KITTITAS COUNTY

MEMORANDUM

TO: All Staff
FROM: Public Works Shoreline Review Team
DATE: July 2, 2025
SUBJECT: SX-25-00004 Hall

<h2>Floodplain</h2>		
Kittitas County GIS		<h1>2025</h1>
Coordinate System: NAD 1983 StatePlane Washington South FIPS 4602 Feet

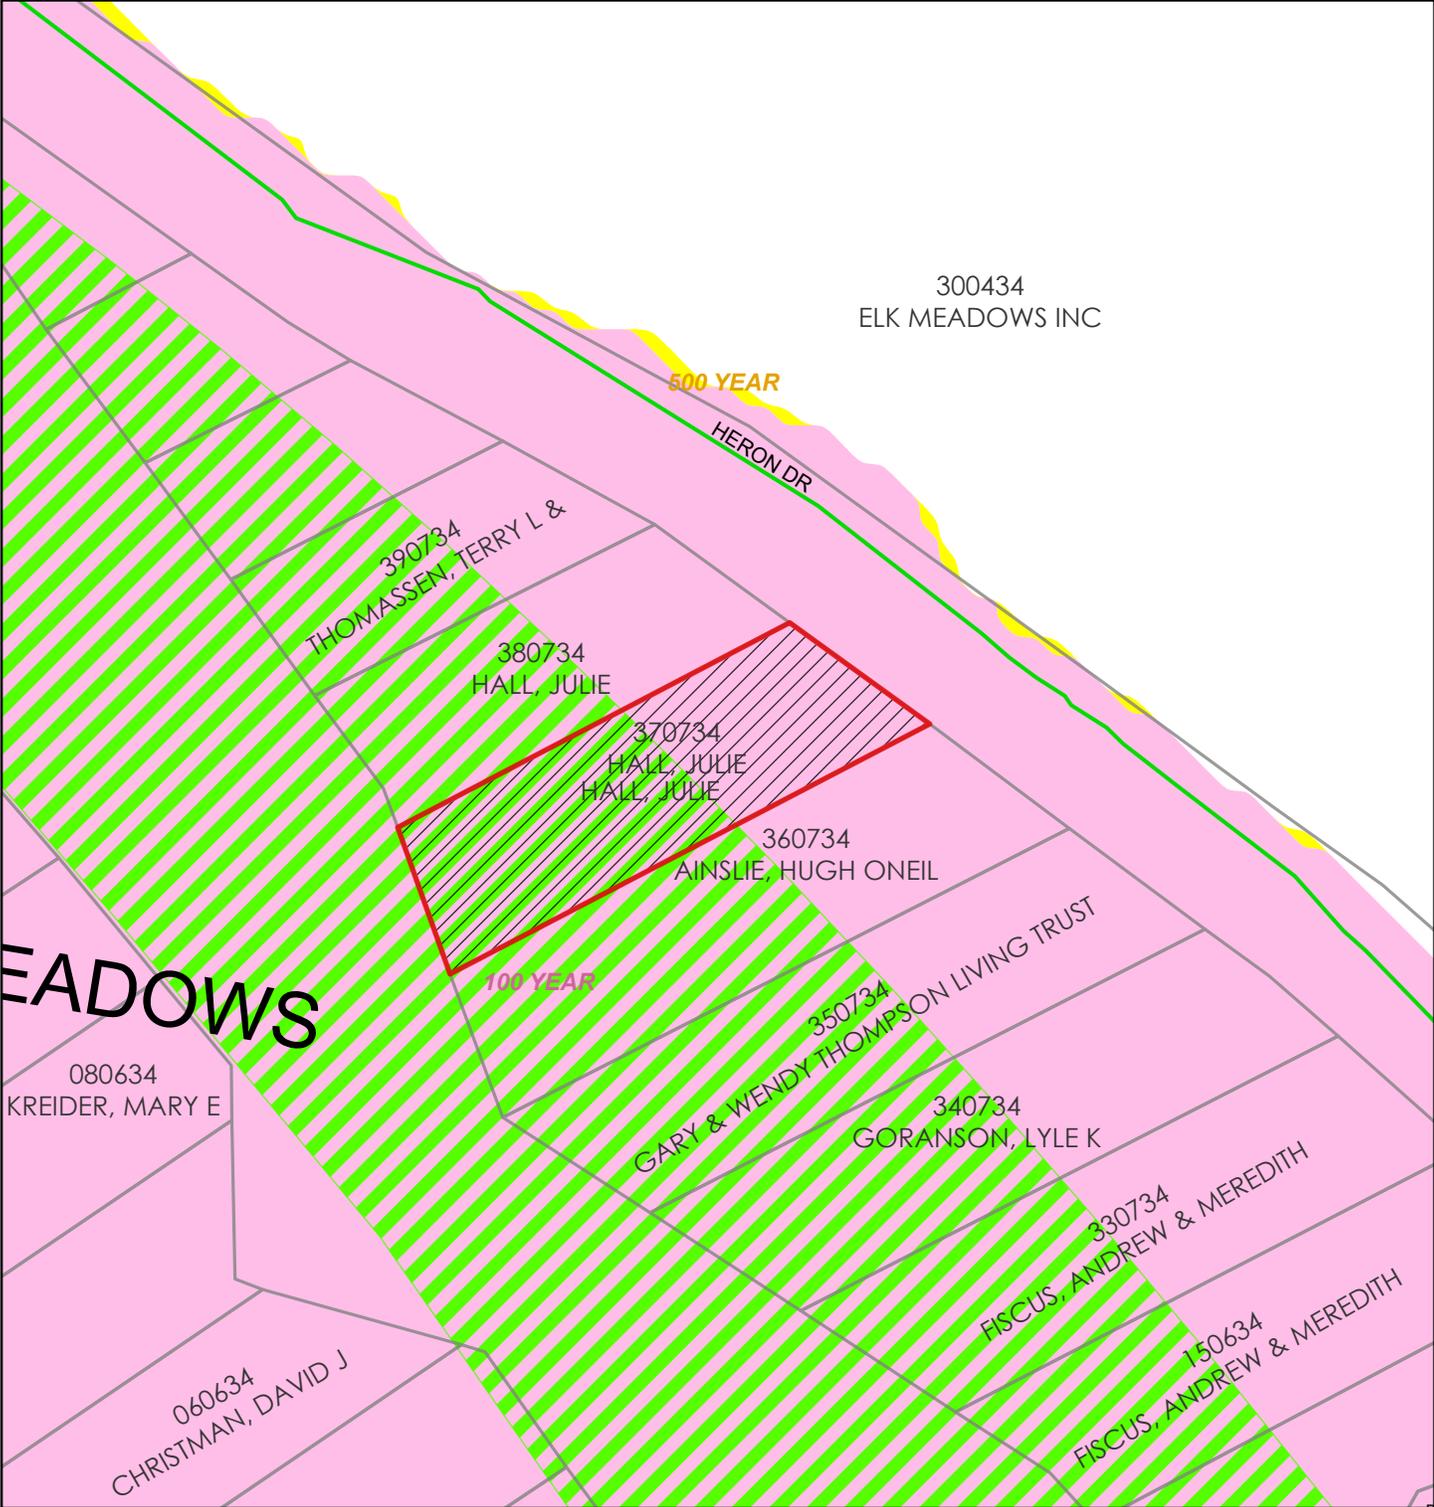
ENGINEERING	Except as exempted in KCC 14.05.060, no grading or filling upon a site involving more than one hundred (100) cubic yards shall be performed without a grading permit from the County Engineer or Public Works designee (KCC 14.05.050). An application for grading in excess of five hundred (500) cubic yards shall be accompanied by an engineered grading plan (KCC 14.05.080). (CBP)
FLOOD	The proposed development requires a floodplain development permit and must meet KCC 14.08 requirements. Public Works has issued a floodplain development application for the project (FD-25-00004) that is under review. The parcel contains FEMA designated floodway. Per the submitted site plan, the proposed house is located outside the floodway. Please be advised that the floodway is highly restricted and any development within the floodway must be permitted through a floodplain development permit and must demonstrate no rise of 100-year flood elevations before being permitted. No new or substantially improved residences are allowed within the Floodway. (SC)
